December 10, 2019

Mr. Jim McGrady, District Manager
Triview Metro District
16055 Old Forest Point, Suite 300
Monument, CO 80132

Re: Review of Grandwood Development

GRANDWOOD RANCH			
PRELIMINARY PLAN - PCD FILE NO SP195			
PLAN SHEET			
DESIGNED BY: CAP	SCALE: HORIZ 1"=100'	DATE ISSUED: JUNE 2020	DRAWING No. PP 01
DRAWN BY: CAP	VERT.	SHEET 3 OF 6	
CHECKED BY: JA

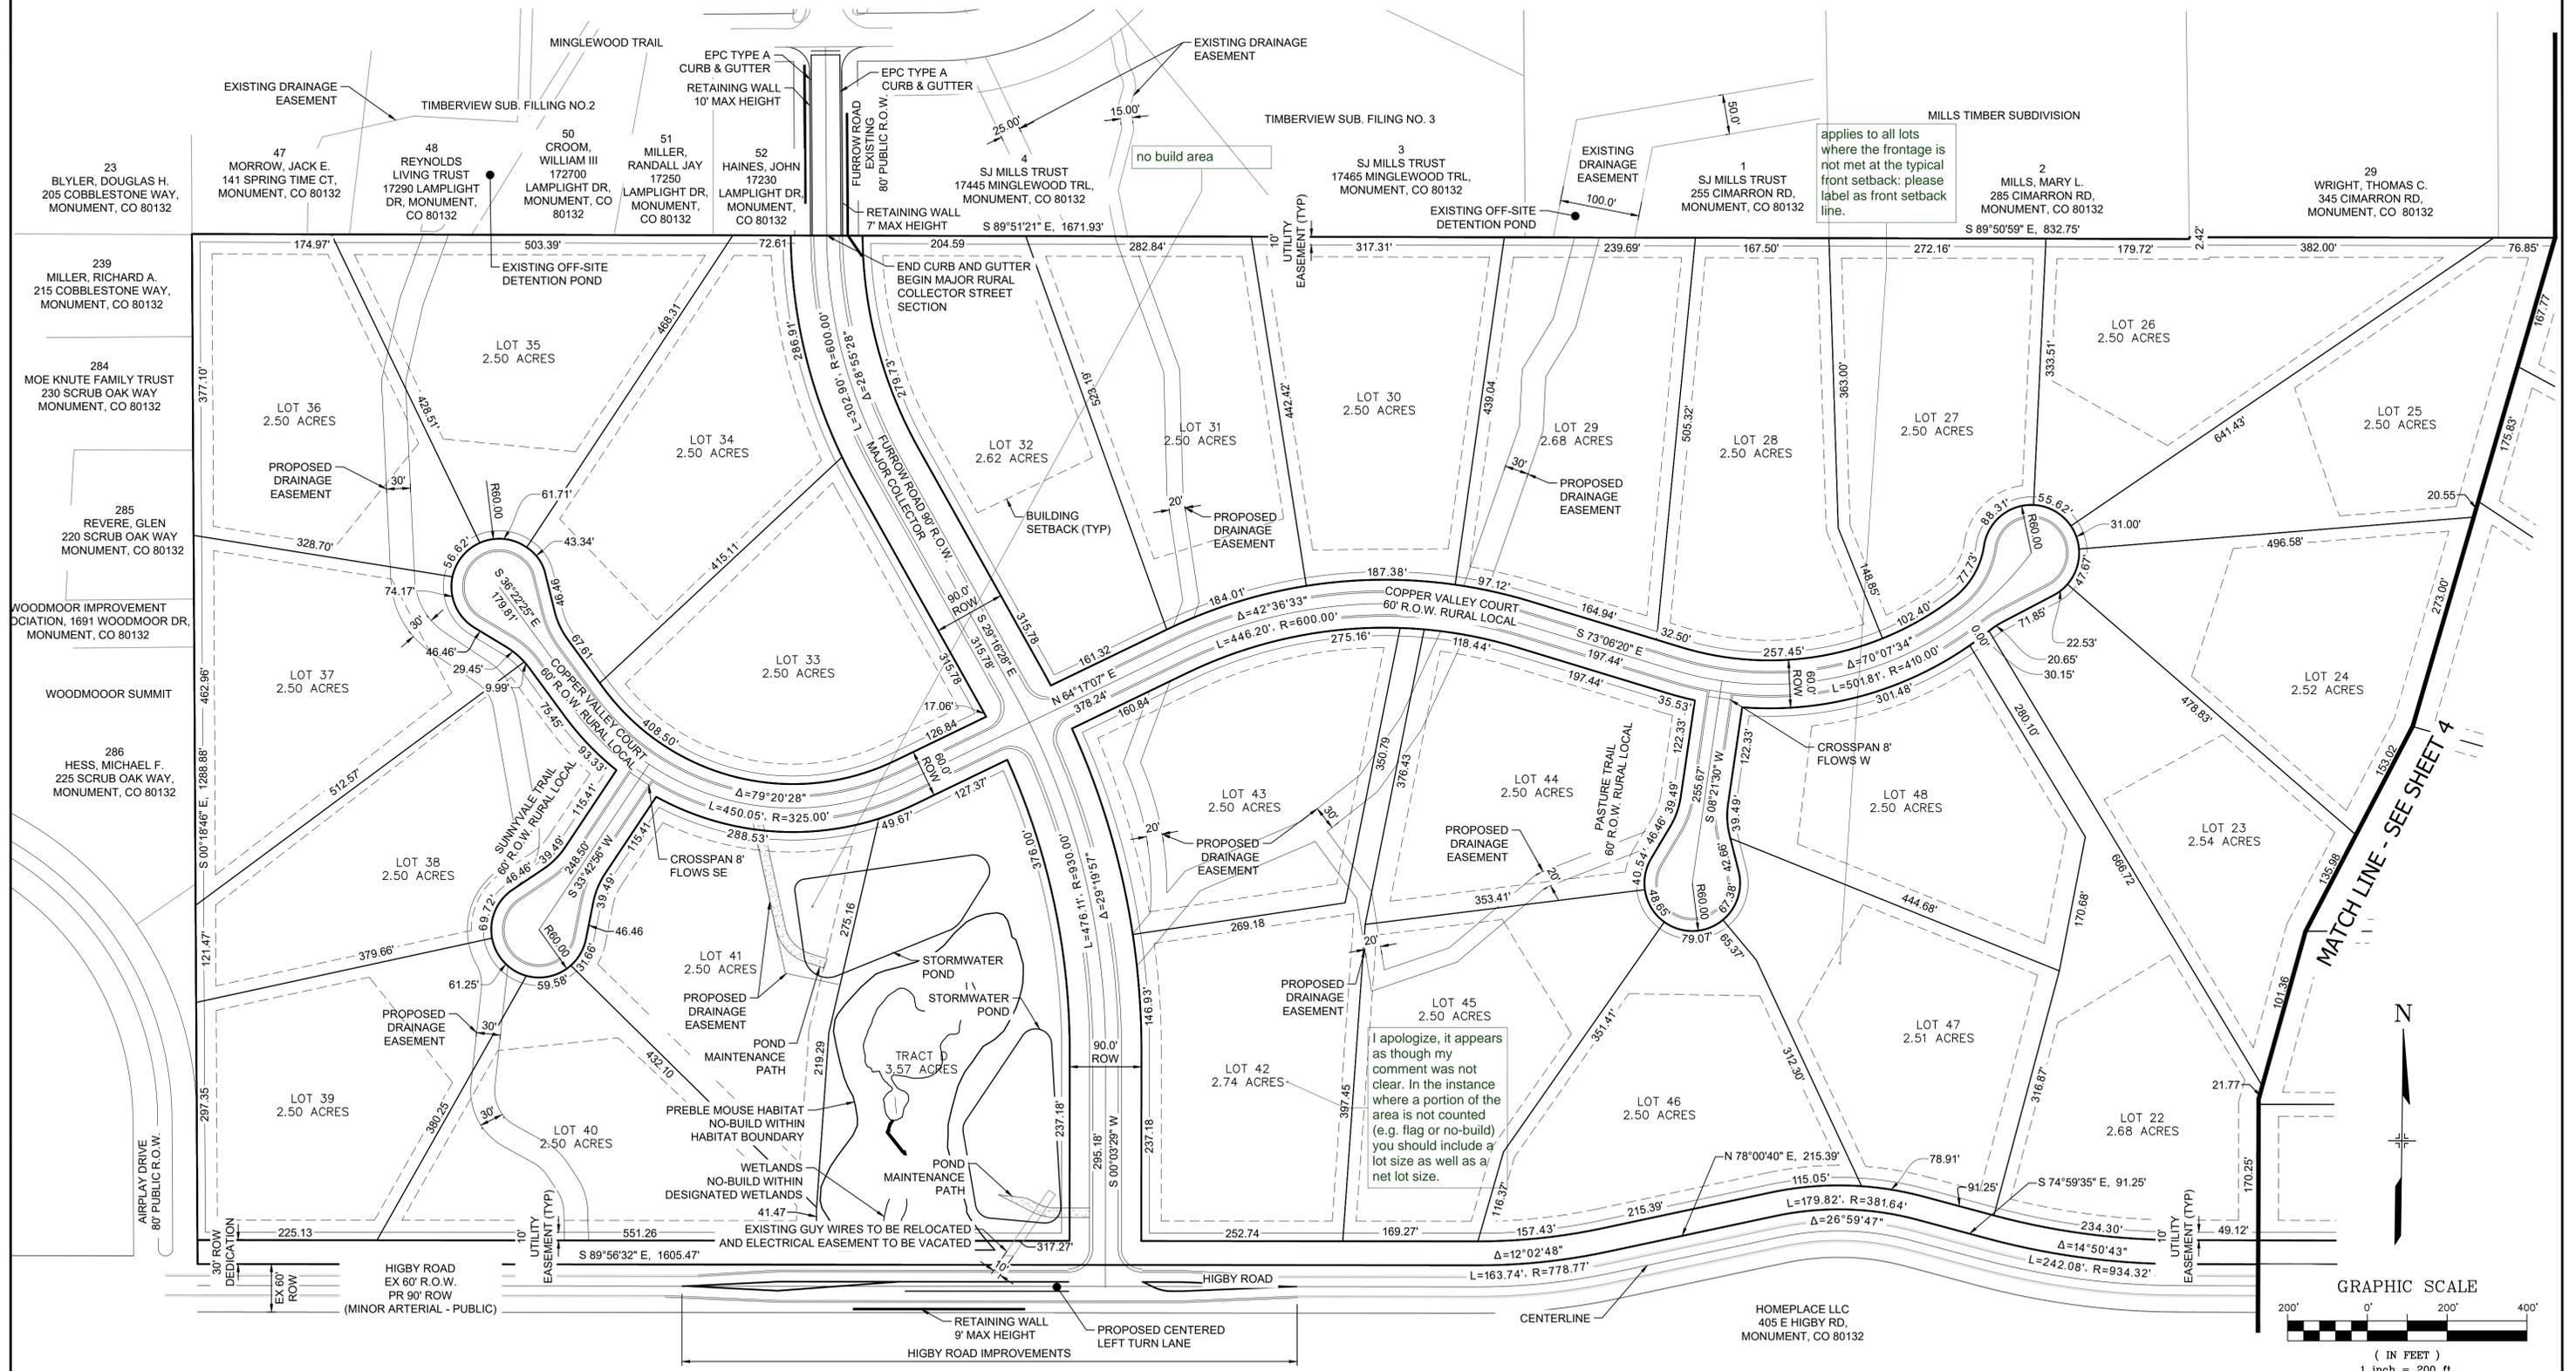
1. Developer should modify eastern roadway to align with Colonial Park Road rather than the west side of the cul-de-sac as shown on the plan. (See attached rough drawing.) This effectively reverses which end connects to Higby Road and which one terminates at a cul-de-sac.

4. Right of way should be dedicated for anticipated road improvements including a 120 foot diameter roundabout with appropriate approach angles at Furrow Road and Higby Road and right and left turn lanes at the Grandwood Drive intersection with Higby Road.
